From: Charlotte Easton
Sent: 25 April 2019 14:55
To: Planning Scanning
Subject: FW: FW: WA/21/19/CLP - 3 Burch Grove, Walberton

I write to you regarding the certificate of lawfulness you have submitted for a replacement single storey rear extension at 3 Burch Grove, Walberton – reference WA/21/19/CLP.

3 BURCH GROVE
PROPOSED REAR EXTENSION UNDER PERMITTED DEVELOPMENT RIGHTS
WALBERTON . WEST SUSSEX . BN18 0BB
PROPOSED ELEVATIONS

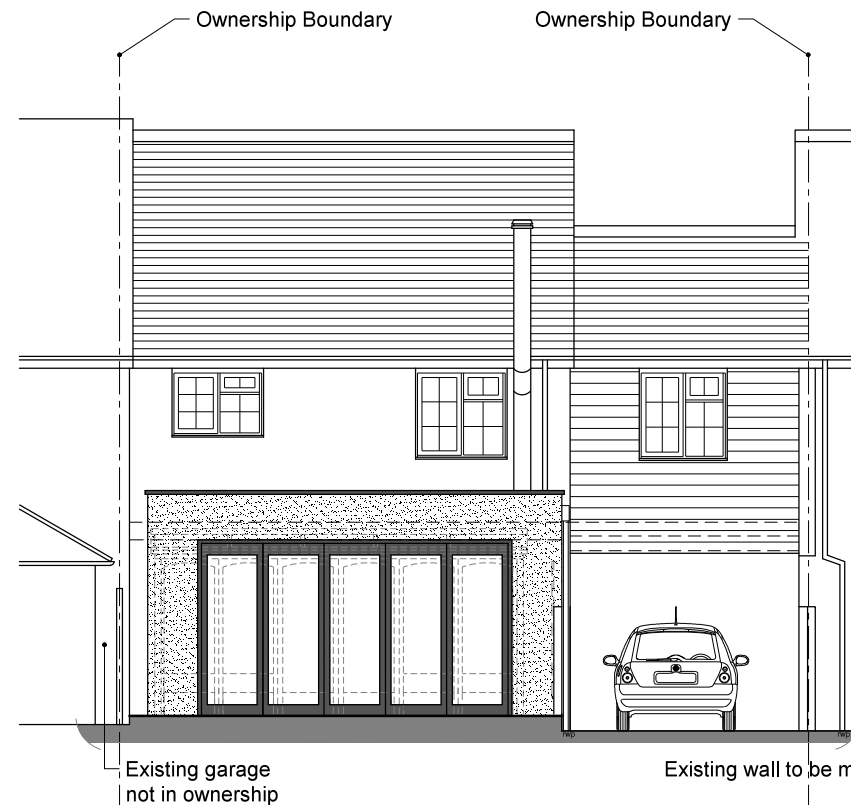
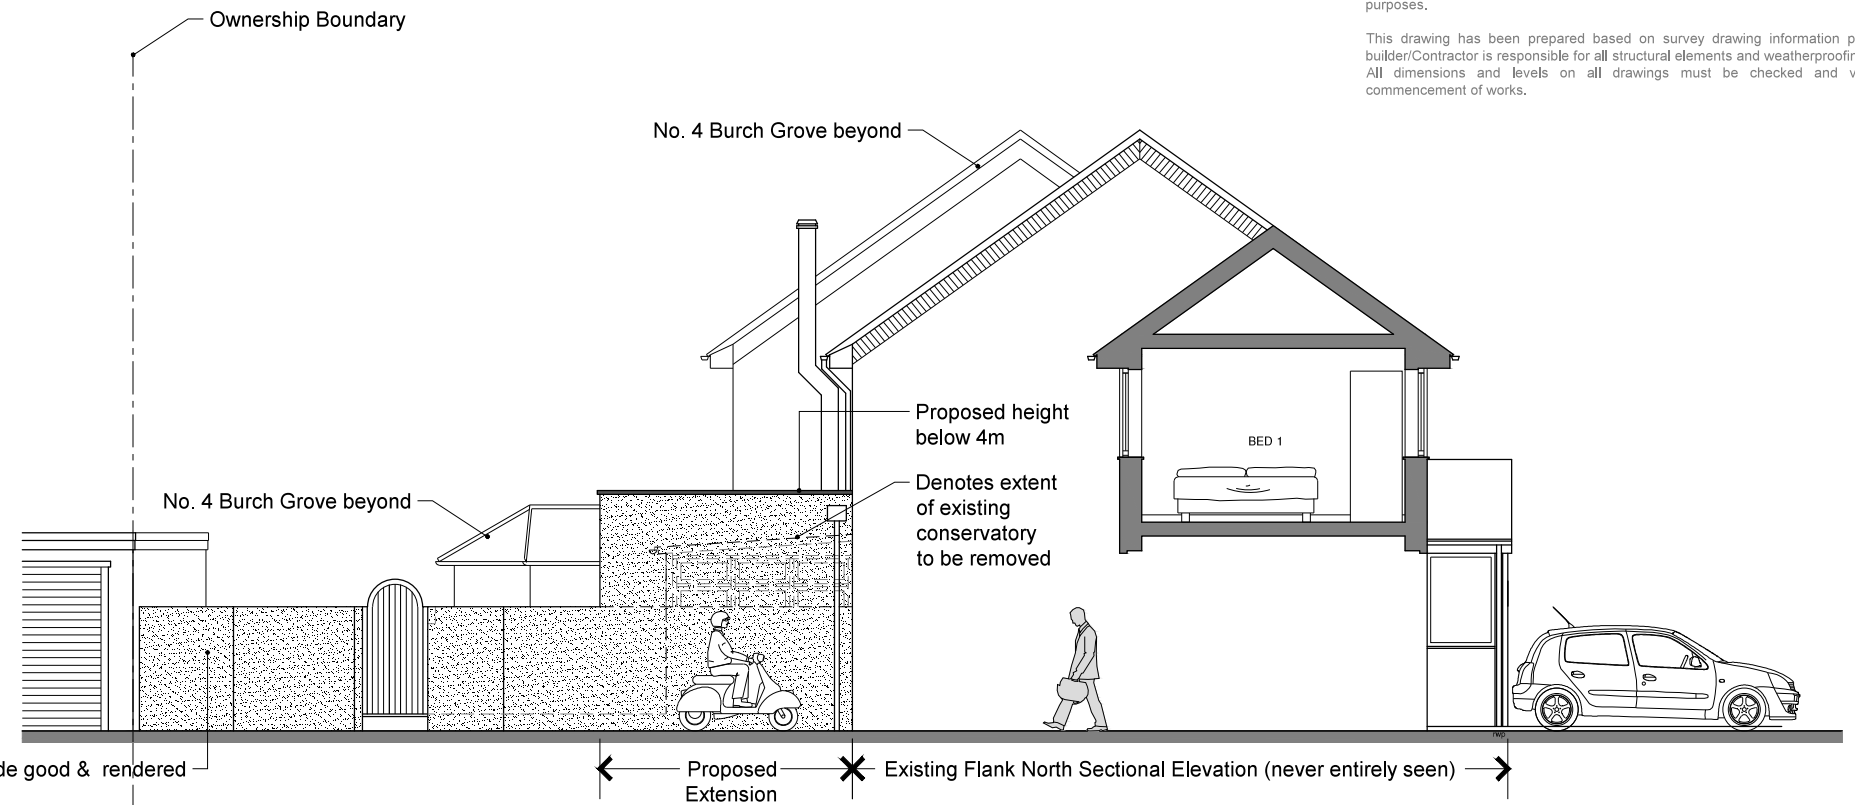
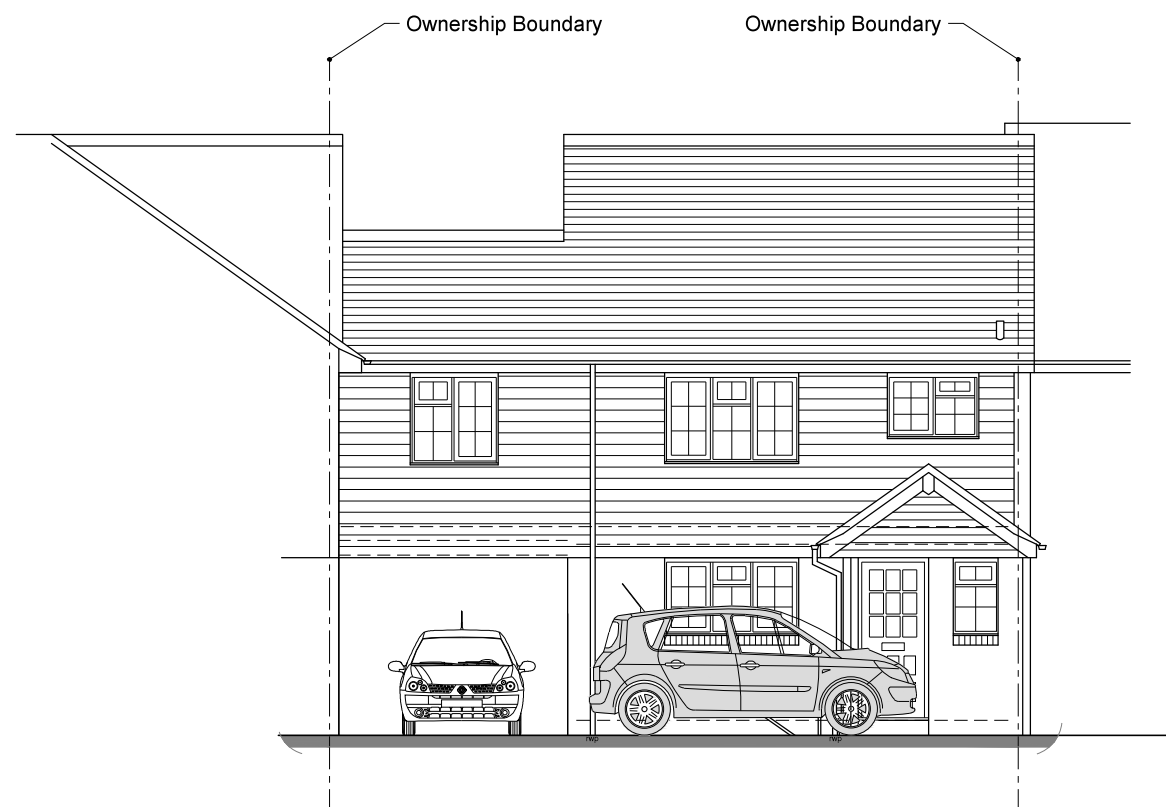
I have started to look at your application and have a query regarding the materials proposed for the replacement rear extension, could you please confirm if the materials proposed will be of similar appearance to those used in the construction of the exterior of the existing dwelling house?

The rear of the property is a brick construction, in what I believe is the now discontinued 'midhurst white' brick.

It is our intention to construct the walls of the extension with block, and then have these rendered in a similar shade to the grey/white appearance of the current brickwork.
